CITY OF ALBUQUERQUE

RE: Cedar Apartments
Grading and Drainage Plan
Engineer's Stamp Date: 10/15/19
Hydrology File: K15D062

Based upon the information provided in your submittal received 10/24/2019, the Grading & Drainage Plan **is not** approved for Building Permit. The following comments need to be addressed for approval of the above referenced project:

RETAINING WALL SECTION 'A-A'

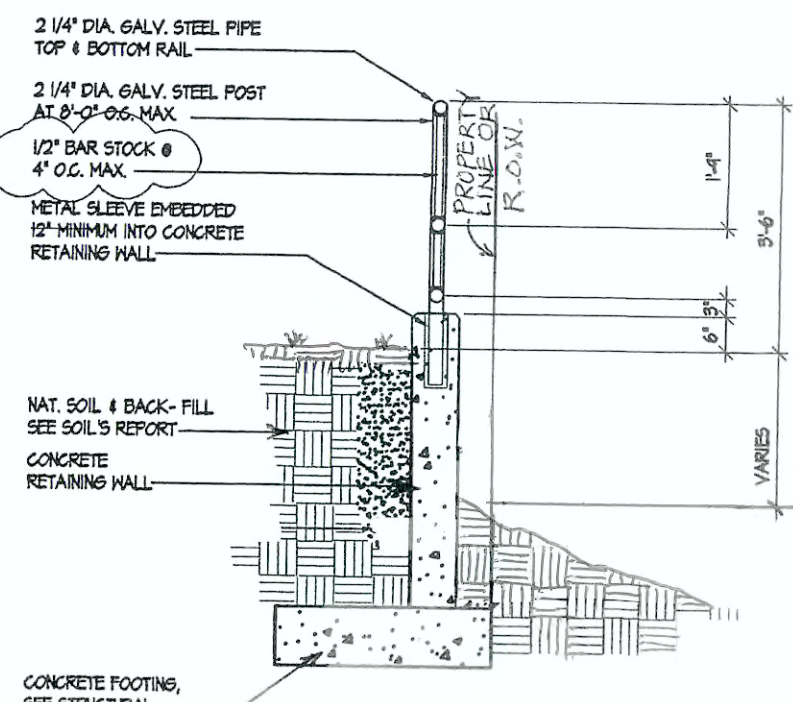
3. There are no drainage facilities being constructed within the R.O.W. so please remove the SO-19 notes.
4. It appears that there are proposed walls along the property lines. Please provide sections through all external boundaries showing proposed retaining walls, garden walls, property/ROW lines, existing and proposed grades. In accordance with DPM Ch.22, section 5 part B, grading and wall construction near the property line may not endanger adjacent property or constrain its use.
5. If the proposed retaining wall will create such an encroachment, written agreement from both landowners must be provided for such work. Written permission must include: signature of the property owner or owners representative, statement that undersigned is the owner or authorized representative, permission to construct the encroachment with a brief description of the encroachment.

GRADING AND DRAINAGE PLAN

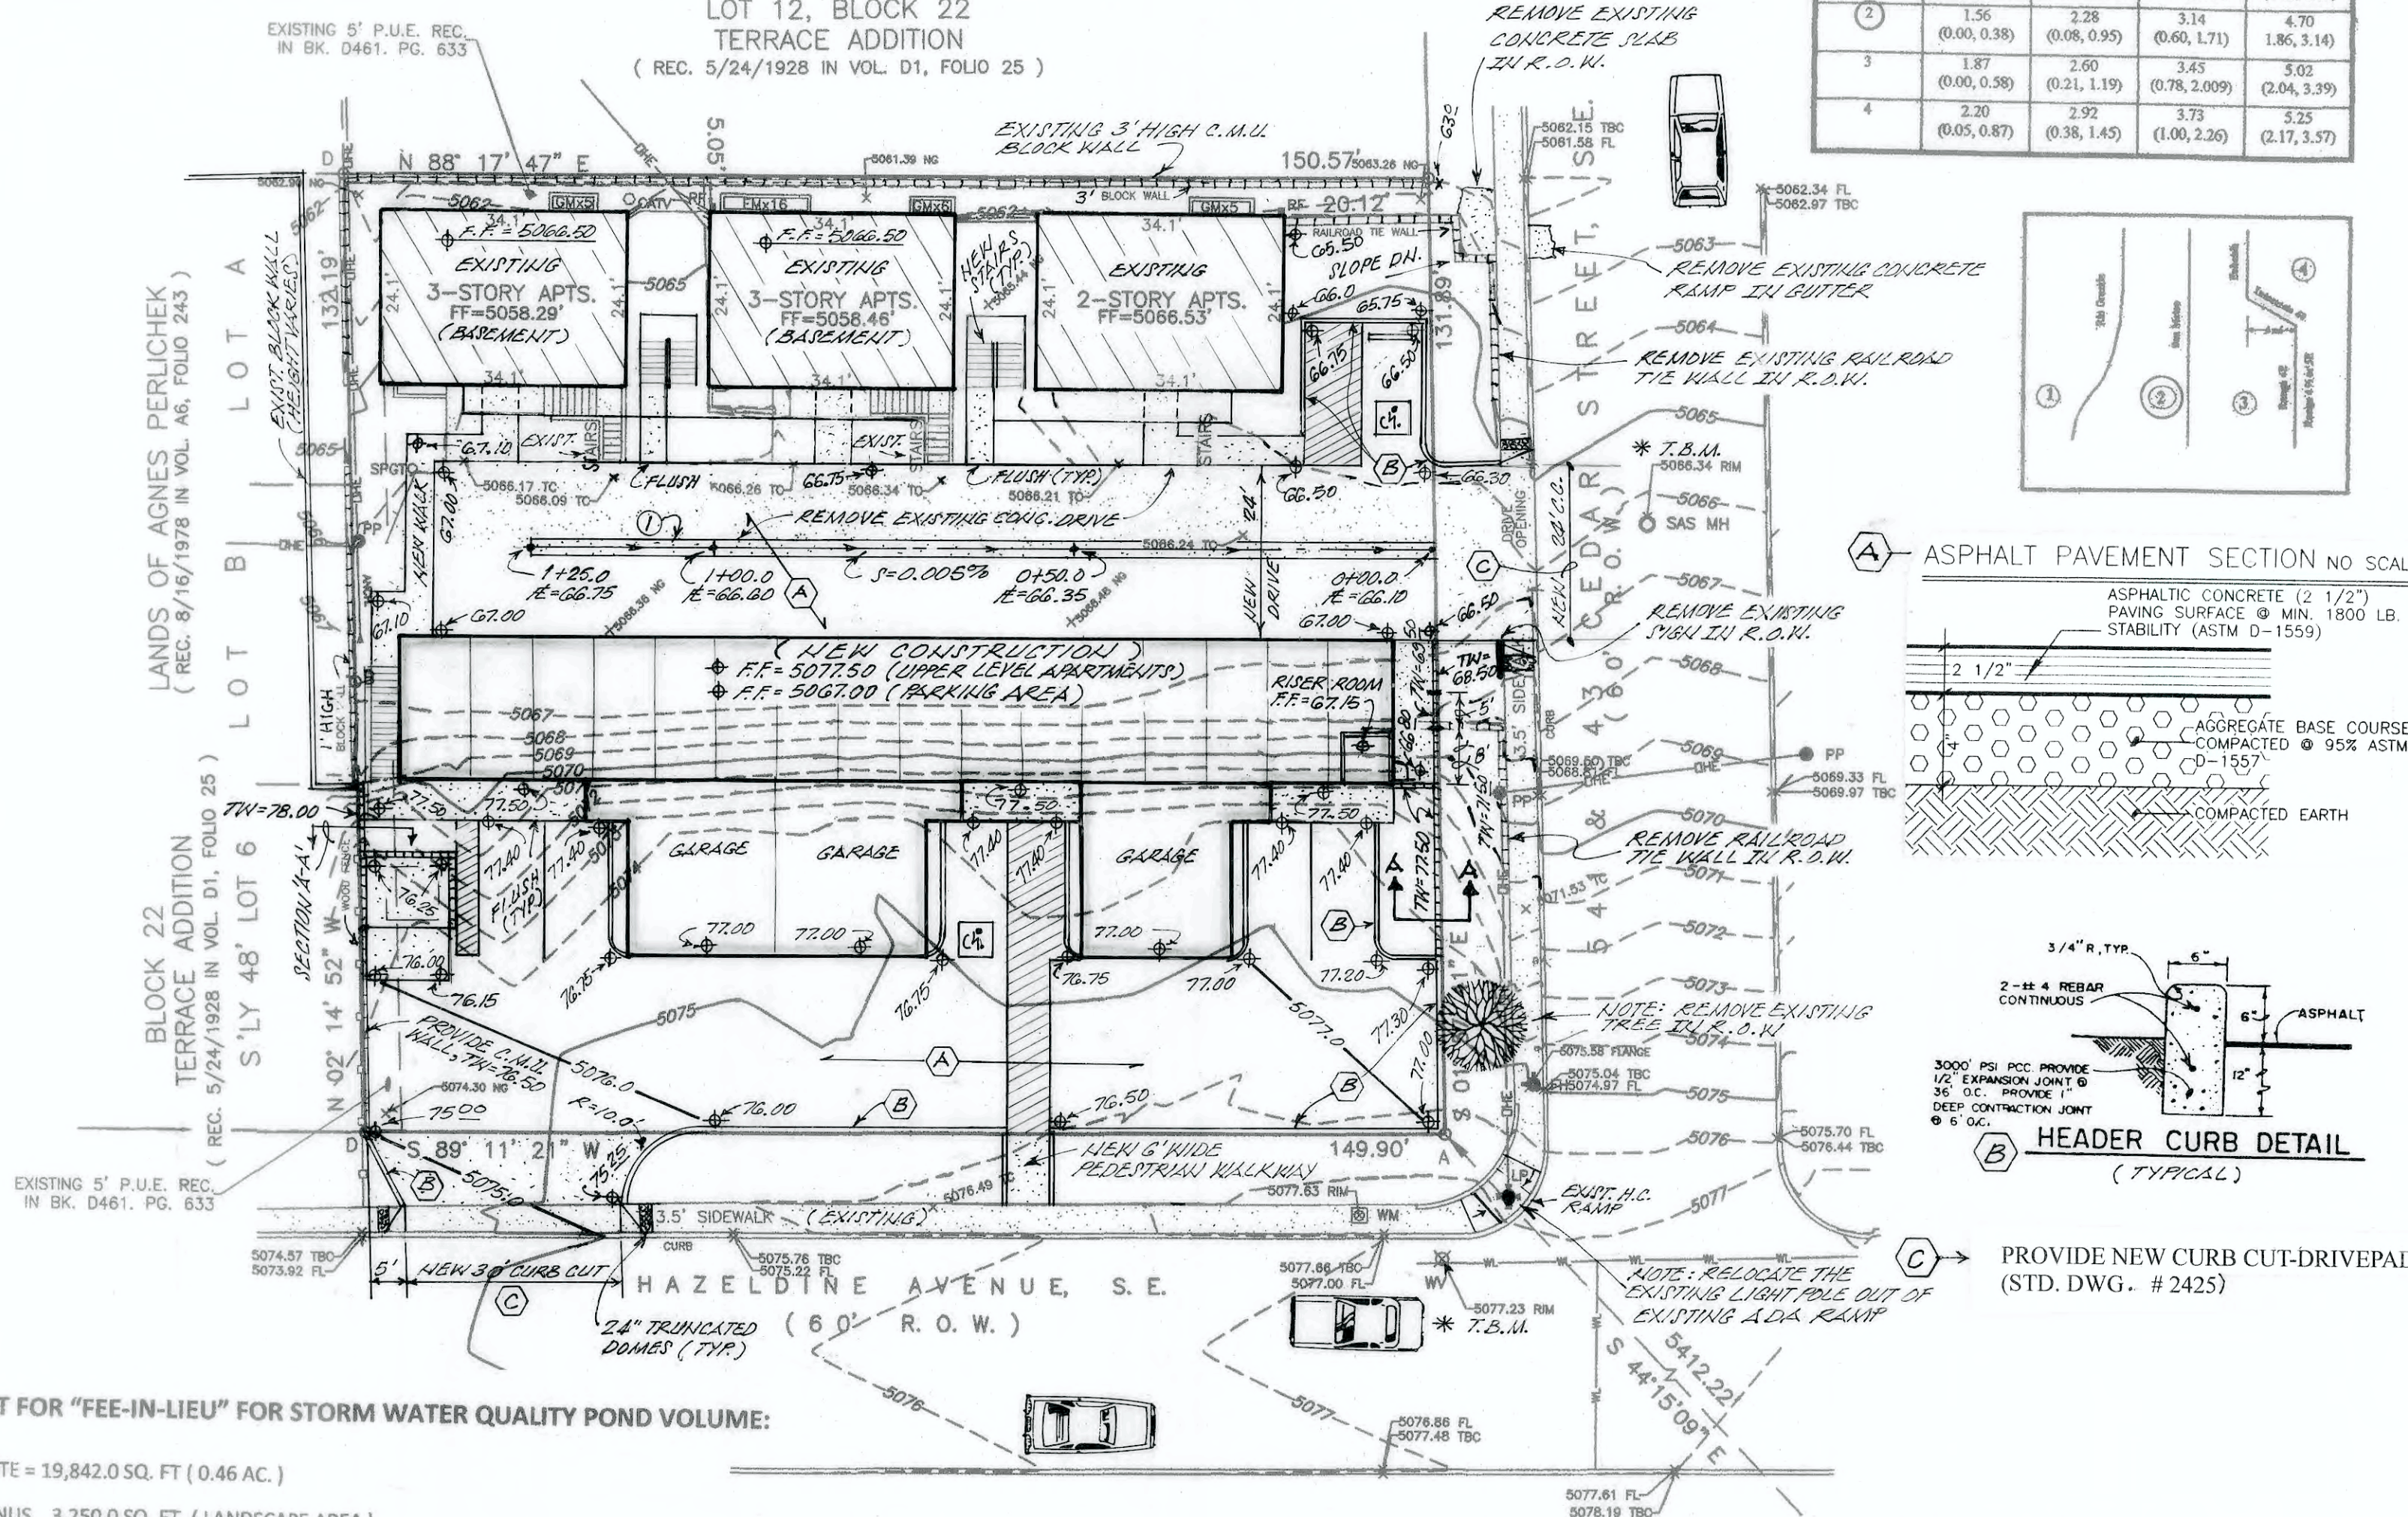
2. Please shade back all existing items. It is very difficult to tell what is existing and what is being proposed.

6. Payment in Lieu (Amount = $359.5 \text{ CF} \times \$8/\text{CF} = \$2,876.00$) of onsite management of the SWQV must be made. Take three copies of the attached treasury deposit slip to the Treasury and then include one copy of the paid deposit slip when resubmitting.
7. It appears that there are several items that were built within the Cedar Street R.O.W. (wood walls, concrete slab, sign, and made ramp in the gutter. Please remove these items and relocate them on the project's property. See photos below.

8. Talking to the Transportation Section, the Grading Plan does not match the approved TCL. Please coordinate to ensure that the plans match.
9. Also please check with the Transportation Section, the drive on Hazeldine Ave needs to be shifted to the east so that the wing of the drive is within the perpendicular line from the property corner. Also the existing light pole needs to be relocated out of the existing ADA ramp at the corner of Hazeldine & Cedar. Also the tree in the R.O.W. needs to be removed as well. See attached photo.
